Our Ref: BN/50/18/PL
Your Ref:

Town & Country Planning Act 1990 (as amended)
Town and Country Planning (Development Management Procedure) (England) Order 2015
Application for Planning Permission

Development Erection of 1 No. replacement dwelling.
Location The Fallows Highground Lane BARNHAM

Drawing 3 - Proposed Site Plan
Scale 1:500 @ A1

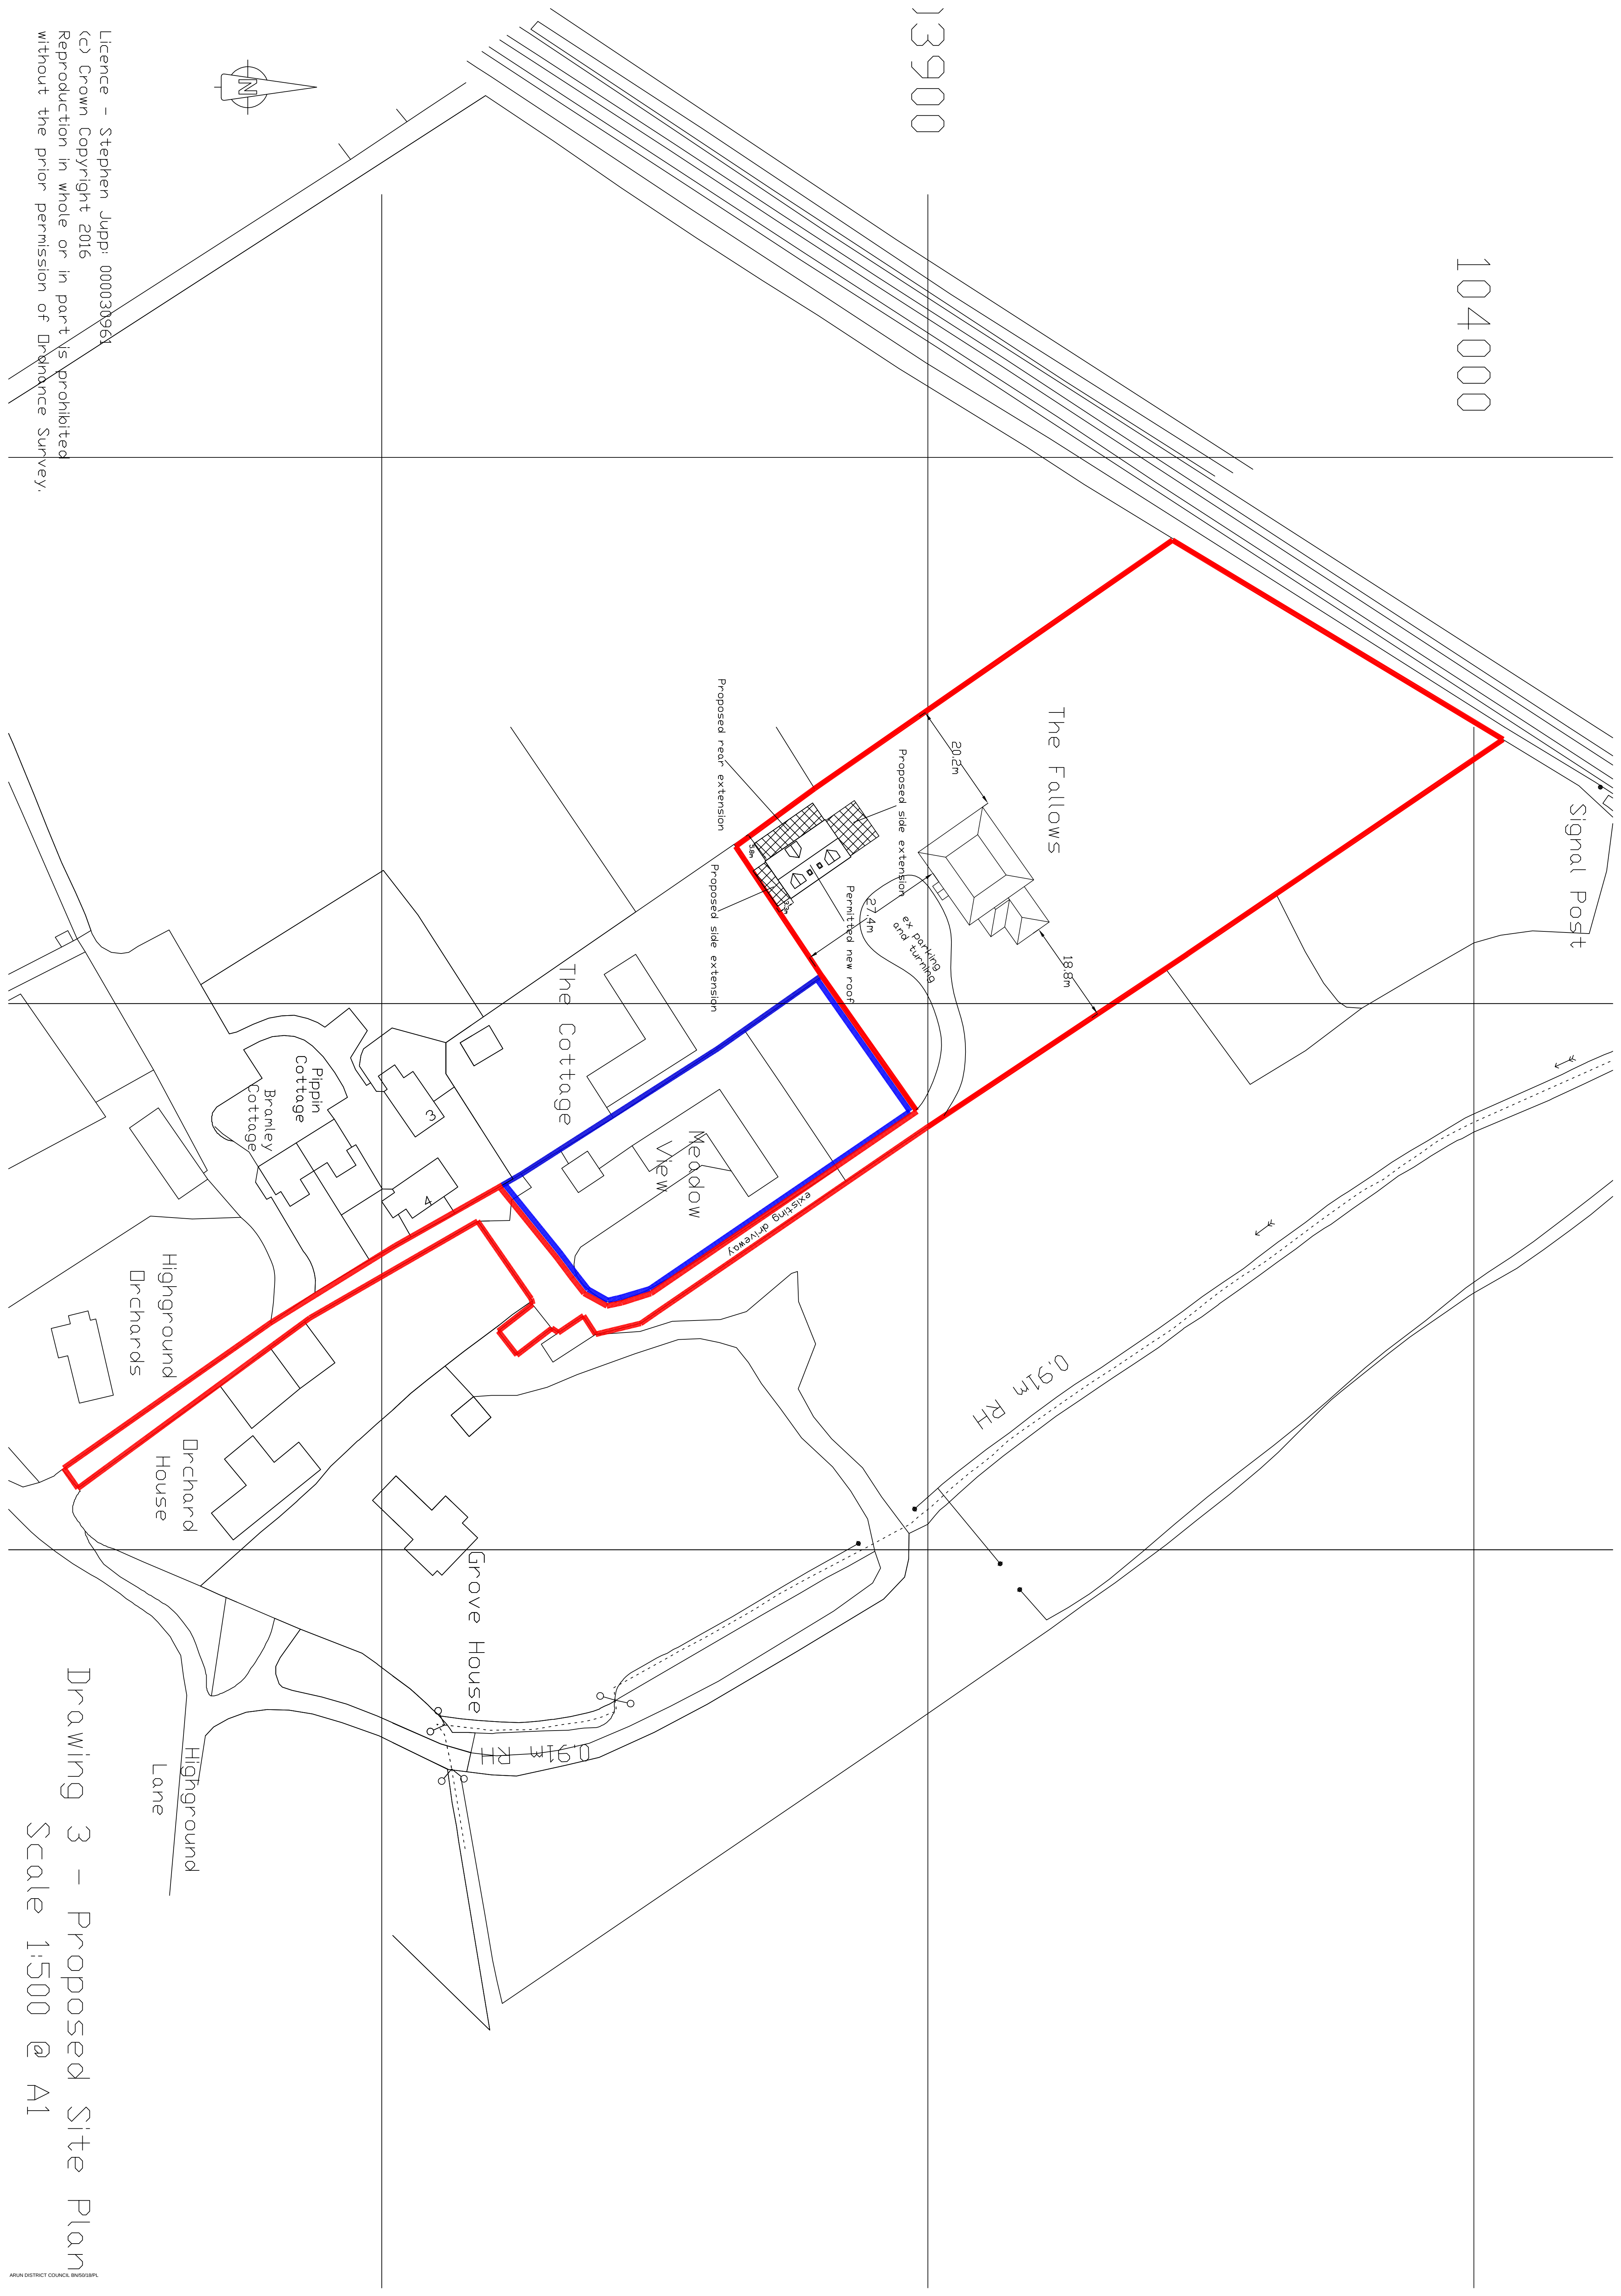
Block Plan Amend

Please provide measurements from the proposal to the site boundaries.
